Subject: 3/2013/0339 - Information Required

Planning Application Reference: 3/2013/0339

Proposal: Proposed change of use of an existing industrial unit to a sports injury clinic

Location: Unit 2 Hall Street Clitheroe Lancashire BB7 1HJ

Existing and Proposed Plan.

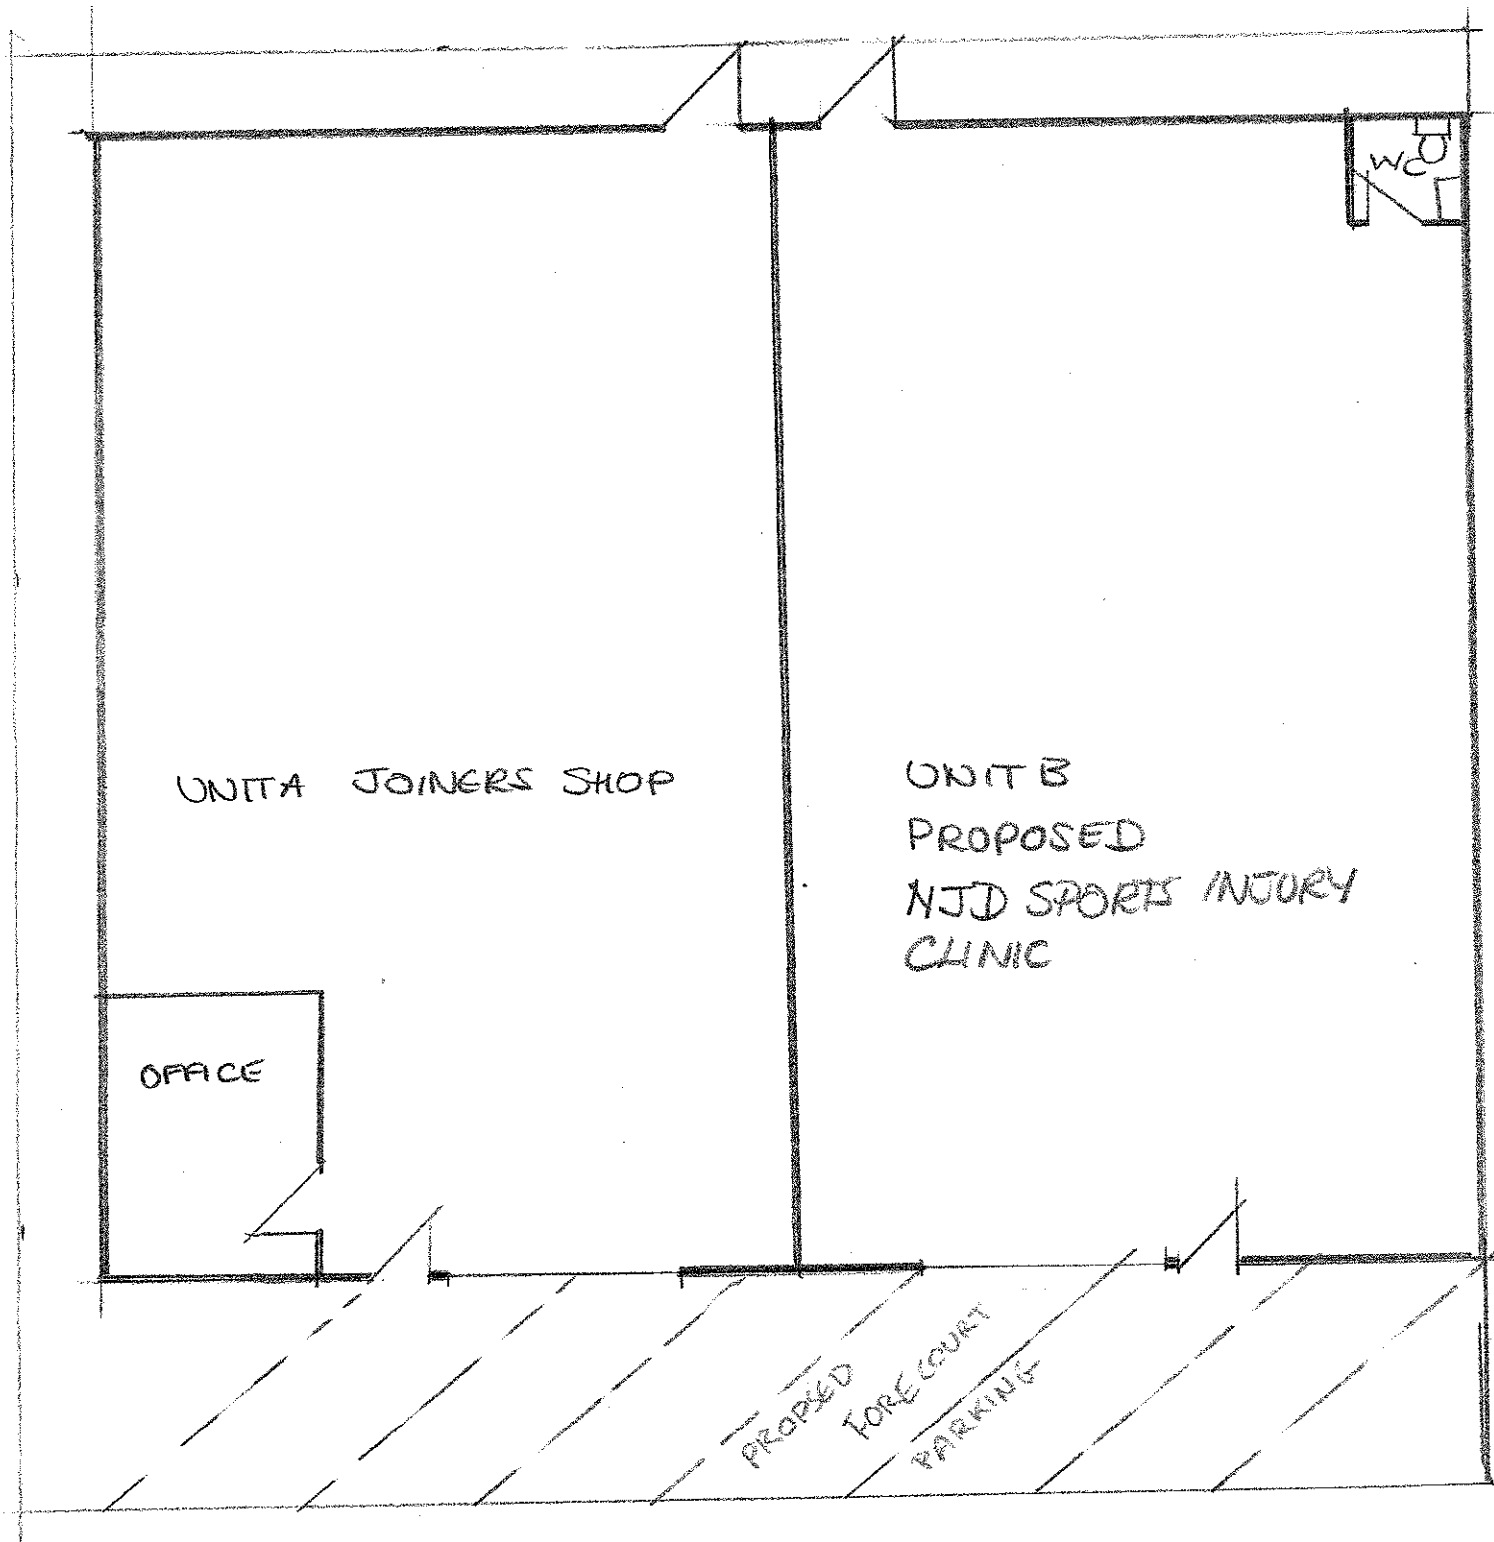
1. How many number of consultation rooms are involved in the sports Injury clinic? Existing parking appears to be limited to only one consulting room.
2. Where will 10 no bicycles parking space be provided? Is it within the building? Externally it is unlikely to accommodate 10 bicycle space in the forecourt area. Forecourt is likely to accommodate 2 or 3 spaces for vehicle parking.
3. External parking layout is required including minimum 1 no mobility impaired space.
